CITY OF ALBUQUERQUE

**RE: Cosme Retail – 6205 Central Ave. NW
Request for Certificate of Completion
Hydrology Final Inspection – Disapproved
Engineer's Stamp Date: 3/15/2017 (K11D077)
Certification Date 1/24/2018**

DESIGNED BY: PMC	DRAWN BY: CCE	CJOB #: BURK-CONSUE	1 OF 1
CHECKED BY: PMC	DATE: 4/20/16	FILE #: C/O	
DATE: 10-12-16	ADDER: GARY GRITSKO	6205 CENTRAL AVE NW	
DATE: 3/15/17	ADDER: GARY GRITSKO	RETAIL SUITES	
		Grading & Drainage Plan

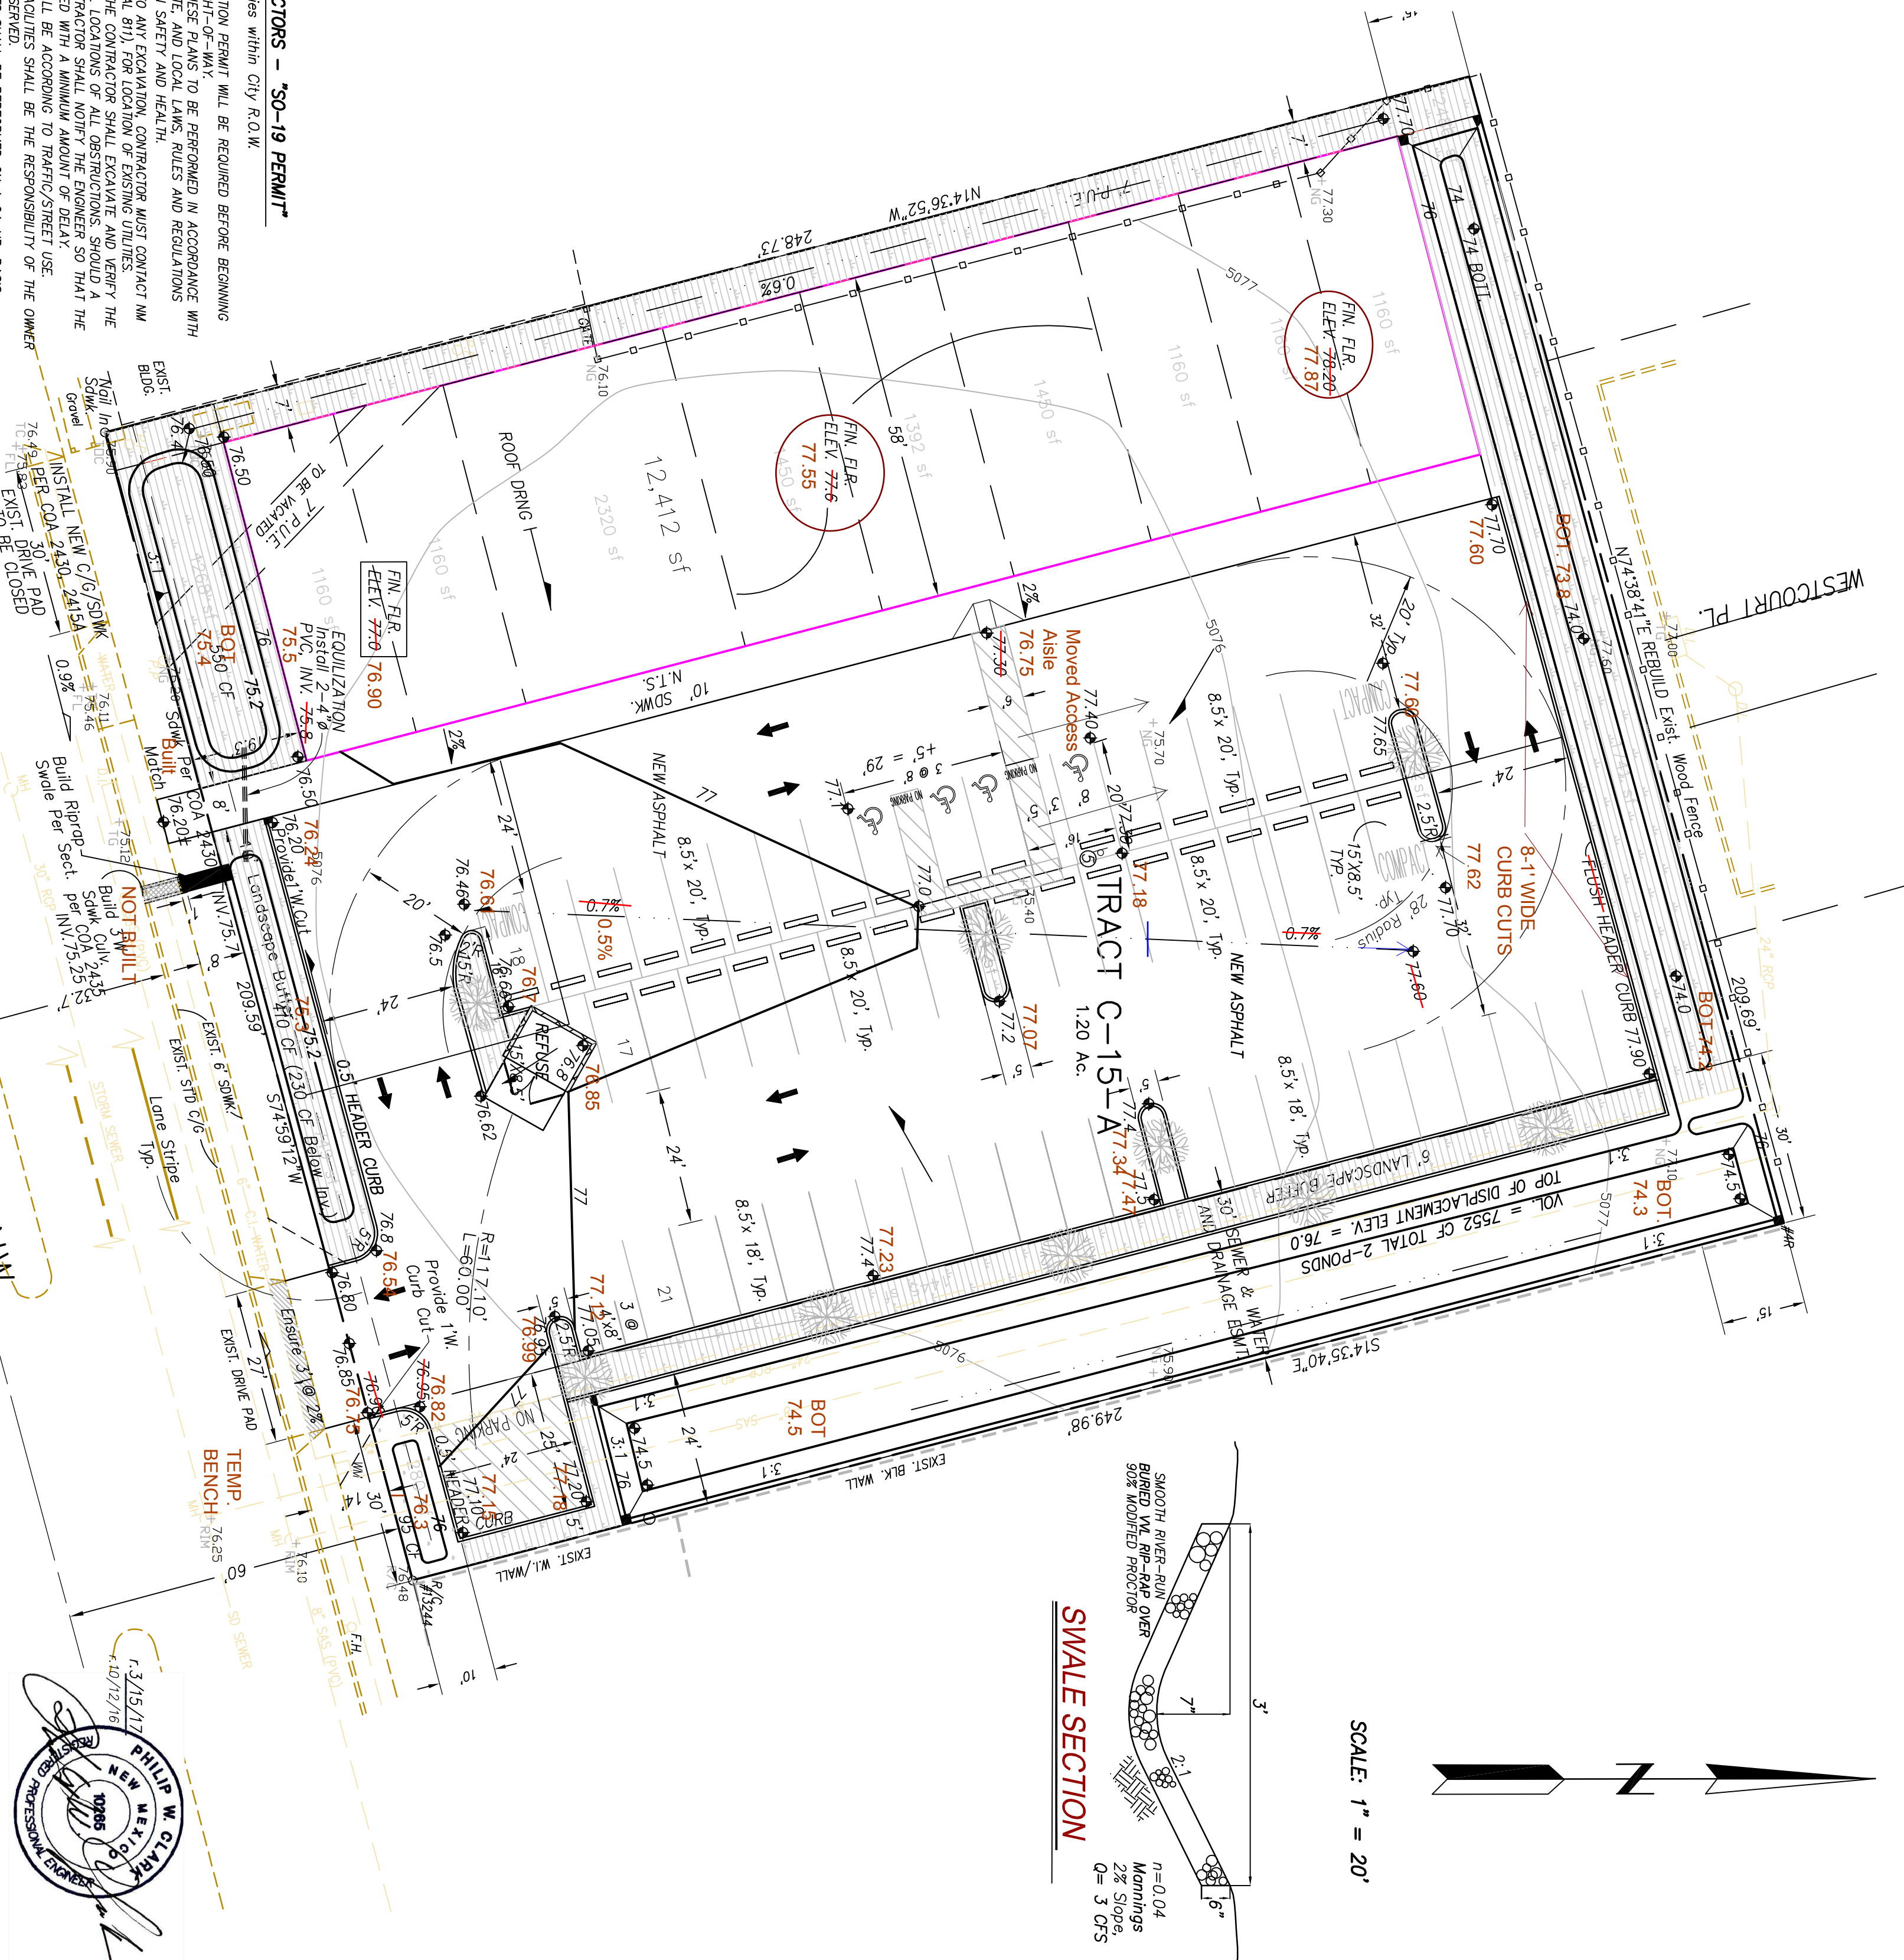
3. The as-built elevations show that the driveway water-block was constructed between 0.13' and 0.26' lower than planned, and may be lower than the COA STD DWG 2425 for Driveways. Dimension L on the standard detail is measured from the top of curb, so both top of curb and property line elevations should be shown on the certification and any deviation noted and justified in the certification statement with supporting calculations on the plan or under separate engineer's stamp.

4. The sidewalk culvert must be built before CO, because we do not allow drainage over the sidewalk on Arterial and Collector streets. An SO-19 permit is required for the sidewalk culvert construction in the public R/W and Jason Rodriguez will need to inspect it after it is complete and send us his approval (see SO-19 notes on the approved G&D Plan).

5. The first flush pond south of the parking lot is missing and needs to be graded per plan. The pond south of the building also lacks volume. The volume below the sidewalk culvert invert must not be less than is shown on the approved plan and must be specifically included in the certification. Extra volume in the other ponds does not compensate for the missing volume in these two ponds. The diameter and inverts of the 4" pipes connecting the two ponds needs verified. Drainage from the parking lot must be prevented from flowing onto the sidewalk connection to Central by adding a header curb between the parking lot and the sidewalk, and a curb cut need to direct drainage from the parking lot into the pond.
6. After these items have been addressed a new application must be turned in with a new DTIS form and the building permit number must be filled in on the form.
